CITY OF ALBUQUERQUE

July 6, 2016

**RE: Lot 15, Block 2, Unit 3, Tract 3, NAA
9000 Eagle Rock Ave NE
Requested for Permanent C. O. – Not Accepted
Engineers Stamp Date 6/29/15 (C20D056B)
Certification dated: 7-1-16**

Based on the certification provided in your submittal received 7/1/2016, the above referenced site cannot be accepted for release of Certificate of Occupancy by Hydrology until the following comments are addressed:

LOT 15, BLOCK 2, UNIT3, TRACT 3, NAA GRADING AND DRAINAGE PLAN

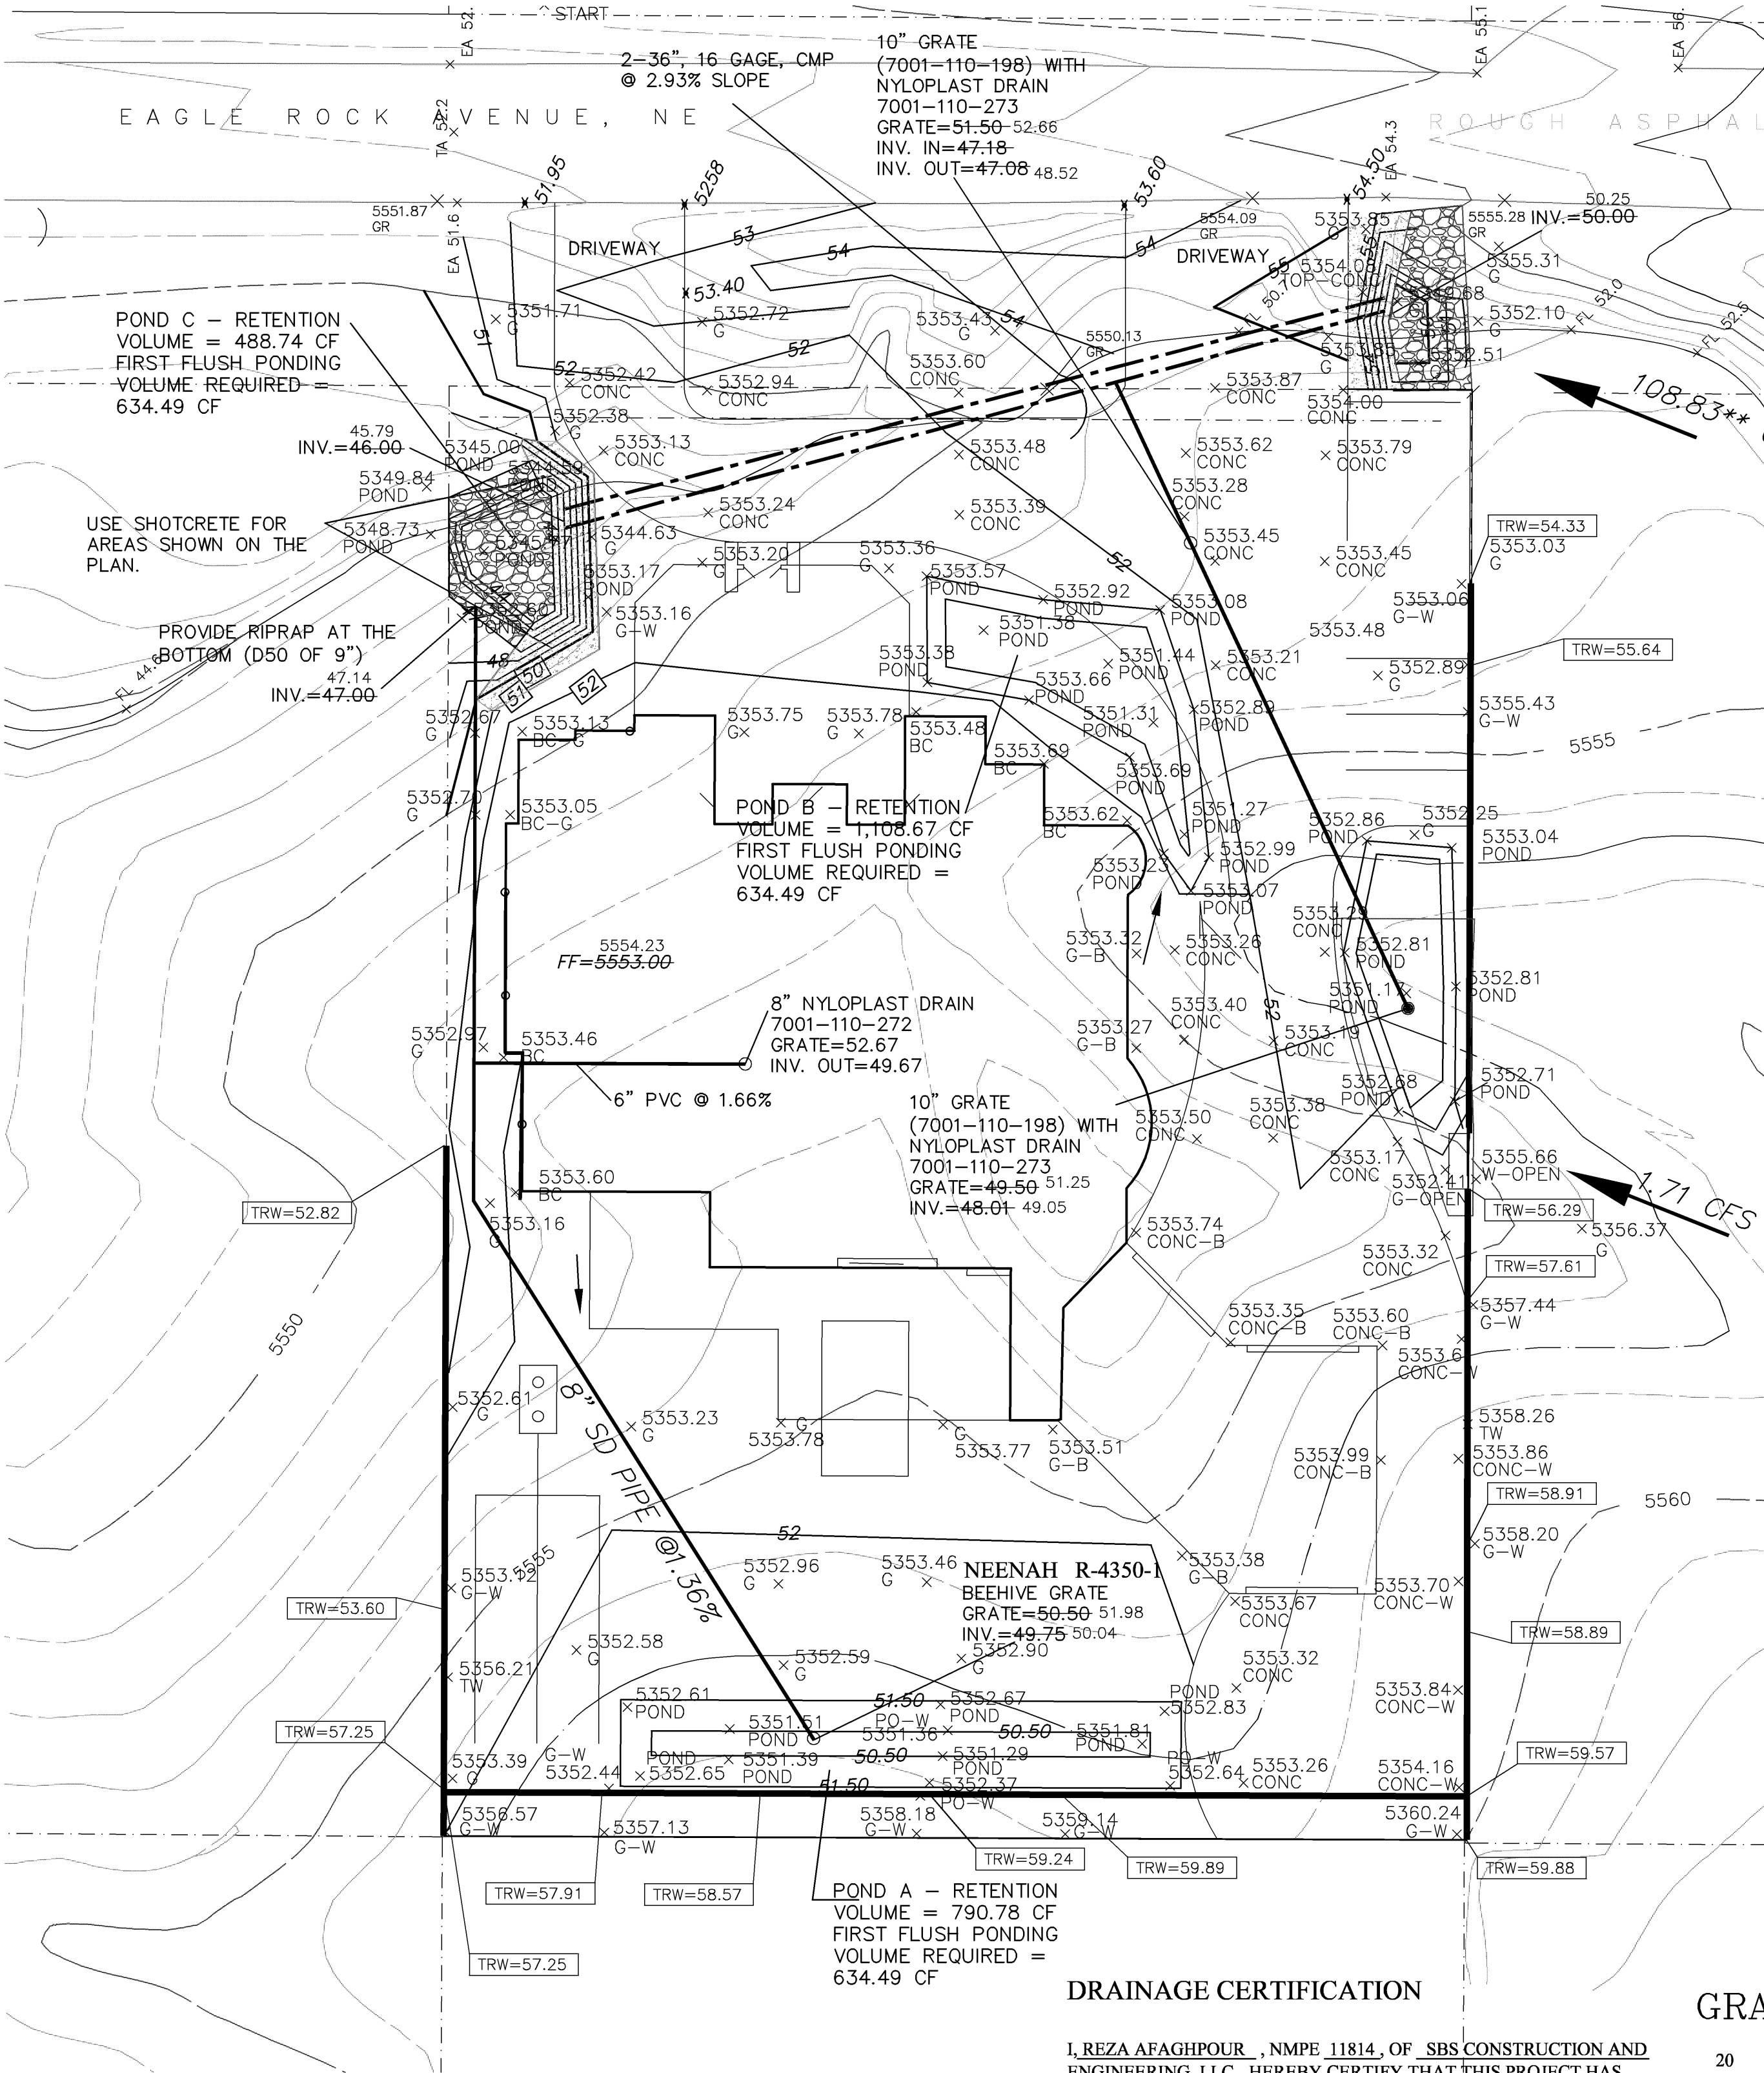
- Pond "A" is not landscaped so a 6" gravel radius needs to surround the inlet. This applies to the pond on the east side of the driveway also.
- Pond "C" must be constructed as designed with 6" shotcrete over 4x4 WWM. This applies to the pond on the NE corner also
- It appears the construction workers have been using the adjacent property to drive into the backyard. Ensure they are not driving on adjacent properties during construction.

An inspection by our office will need to take place after these corrects are made.
